**SSD-8804 (PAE-2882) – PROPOSED HOWLONG SAND AND GRAVEL QUARRY EXPANSION,
4343 RIVERINA HIGHWAY, HOWLONG**

TfNSW has completed a review of the Submissions Report (the Report) prepared by R.W Corkery & Co Pty Limited dated February 2022. Focussing on the impact to the state road network, TfNSW advises the following:

**FIGURE 5-1 REVISED LEVEE ALIGNMENT AROUND EXTRACTION PITS**

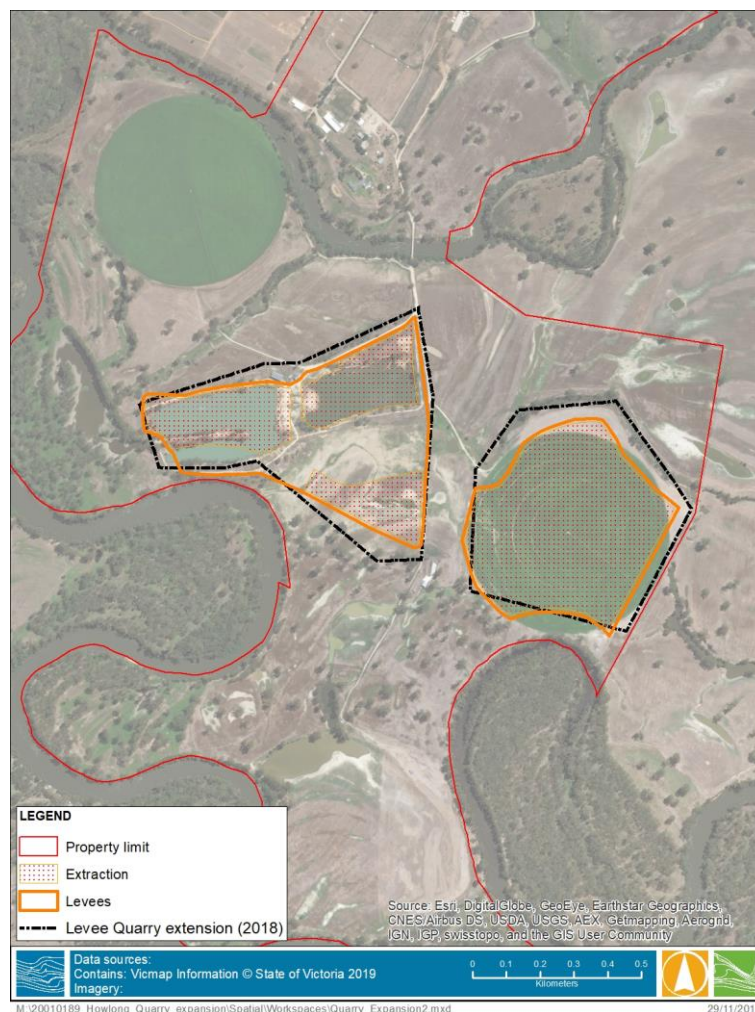
- The Review of Flood Modelling Outcomes prepared by Water Technology November 2021 as per **Appendix 8** of the Report indicates the addition of a levee to prevent the expansion pits from flooding up to a 1% AEP flood event, could result in a minor increase in water levels up to 4 km upstream of the site;
- The flood modelling outcomes indicate that the maximum increase to flood water levels as a result of the levee construction varies from 30cm just upstream of the Quarry Site to approximately 3cm at a point 4.7km east of the upstream modelling boundary;

- The Riverina Highway is outside of the floodplain in this location and is constructed above the 1% and 0.5% Average Exceedance Probability (AEP) depth;
- To ensure that the addition of a levee does not impact the classified road network, TfNSW also recommends that an additional condition be added to ensure that there is to be no flooding of the Riverina Highway as a result of the levee as found in **Attachment 2 of this correspondence**.

1. A survey of the Quarry Site extraction area and on-site stockpiles is to be provided to Council on an annual basis to ensure the extraction does not exceed a maximum of 300,000 tpa.
2. The proposed additional levee to prevent the expansion pits from flooding shall not cause any flooding to the Riverina Highway.
